Project#1008630 Manzano Mesa Tract(s) C
13DRB-70741 Preliminary/Final Plat Approval

9. **Project# 1008630**
13DRB-70682 MINOR - PRELIMINARY/
FINAL PLAT APPROVAL

RE: Tract C, Manzano Mesa

SITE SKETCH FOR TRACT C-1 MANZANO MESA

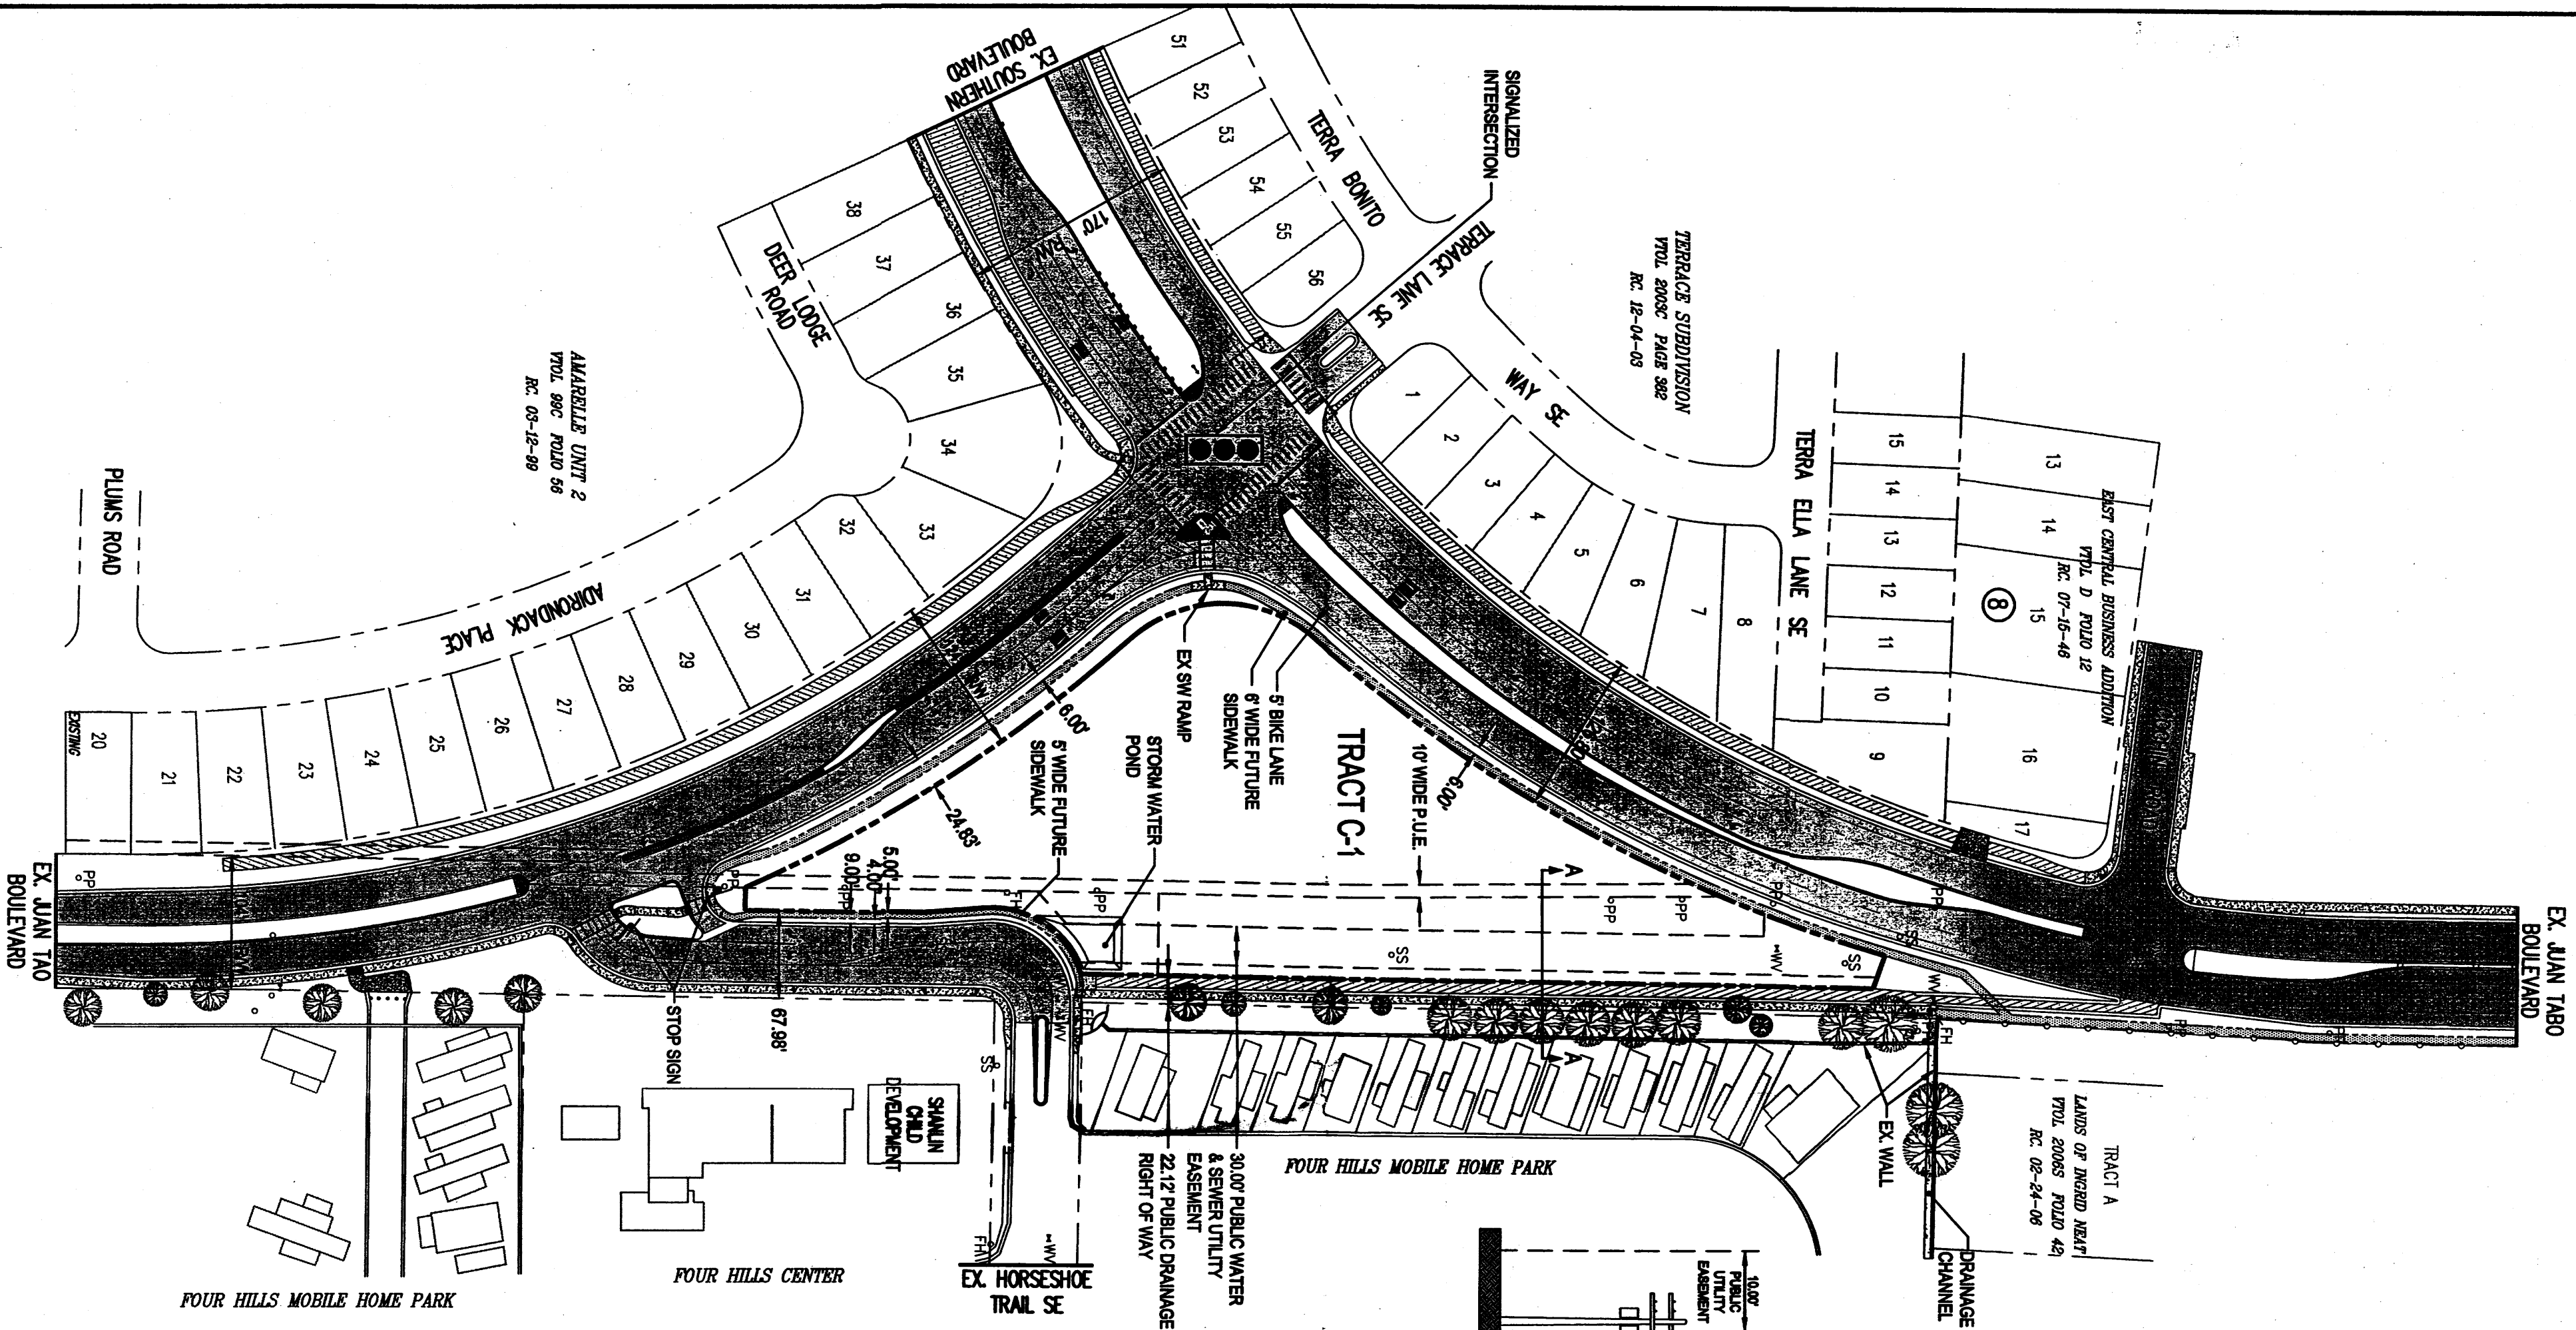
Provide an exhibit showing the location of sidewalk and defining the distance from back of curb to the property line. Right of way dedication may be required.
The site sketch is unclear; clarify existing versus proposed sidewalk.
